**Administrative Amendment Application**  
**City of Charlotte**

**Application for an Administrative Amendment to a previously approved conditional zoning district as per Section 6.207 of the City of Charlotte Zoning Ordinance.**

Associated rezoning petition Number: 2013-099 Zoning: INST. (CD) SPA

Addition of a roof over the existing second floor exterior porch at the Conference Center.

ADMINISTRATIVE AMENDMENT

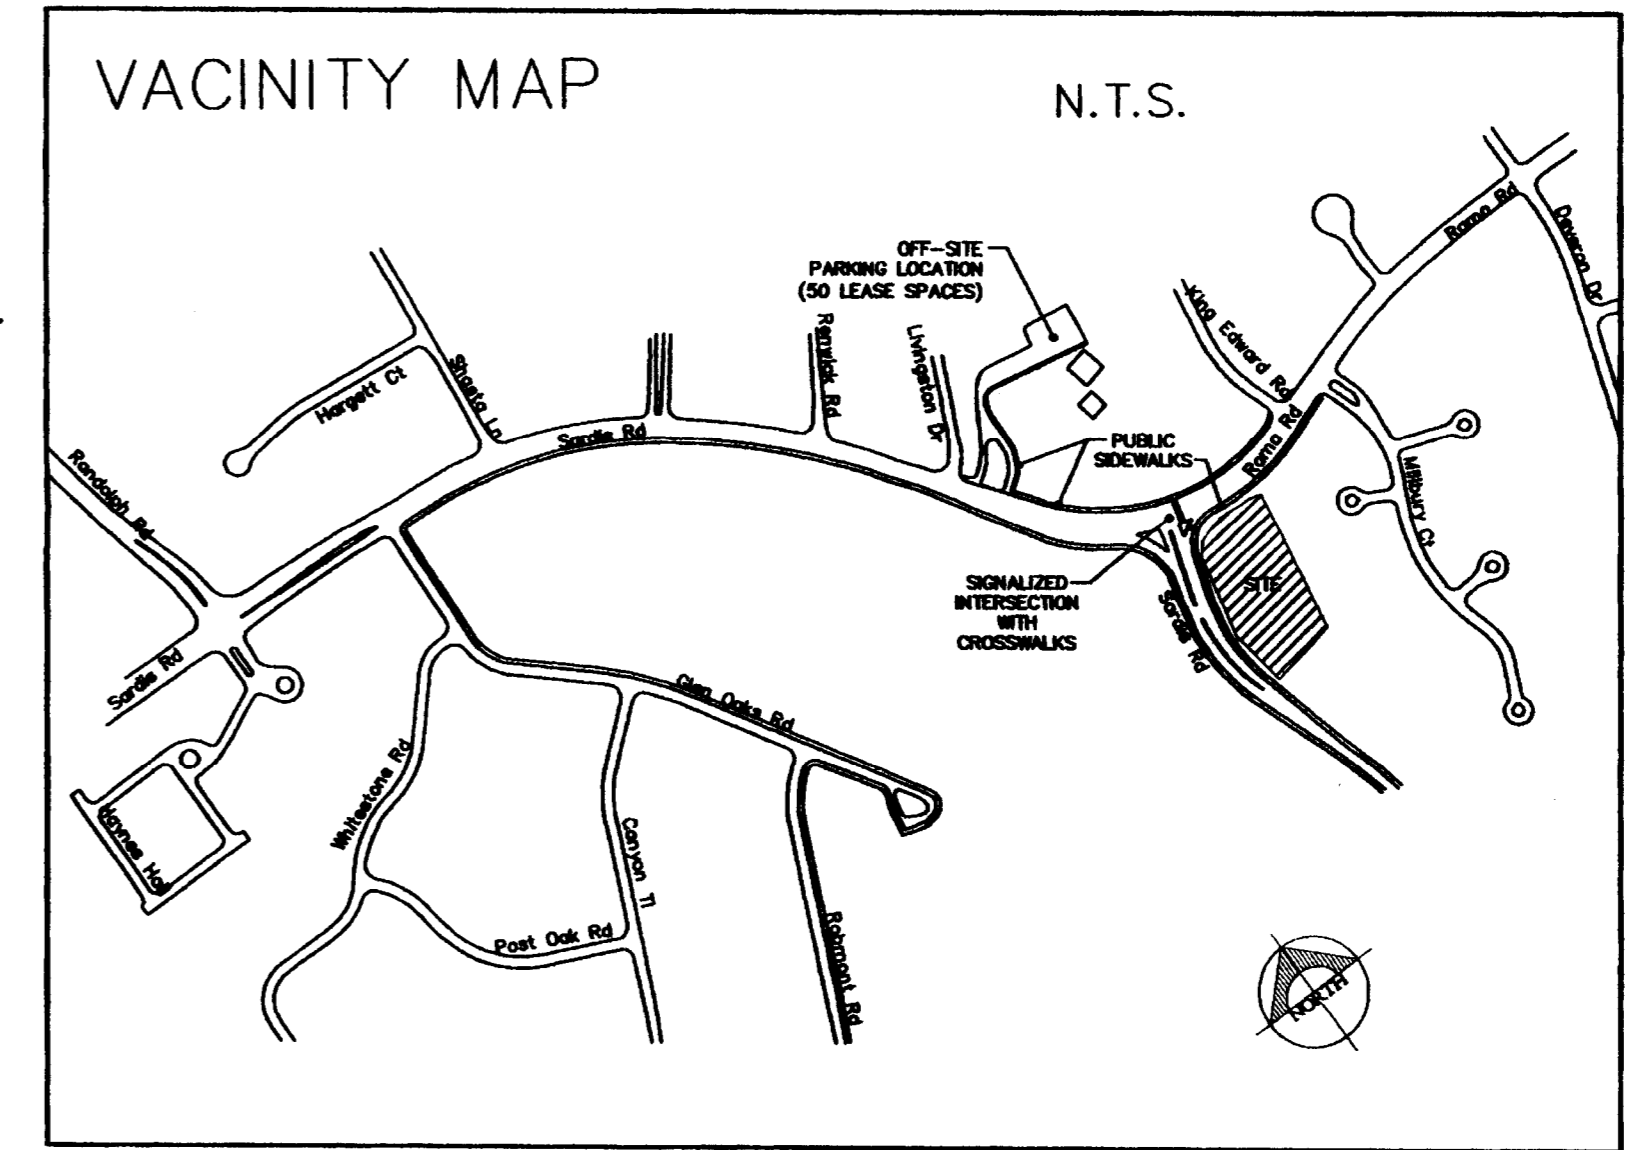
Administrative approval was requested by Kam Merrell while the porch addition was reviewed during MCCE's preliminary plan review process. Solomon Fortune requested that a note be placed on the rezoning plan ensuring the porch would not be heated nor enclosed.
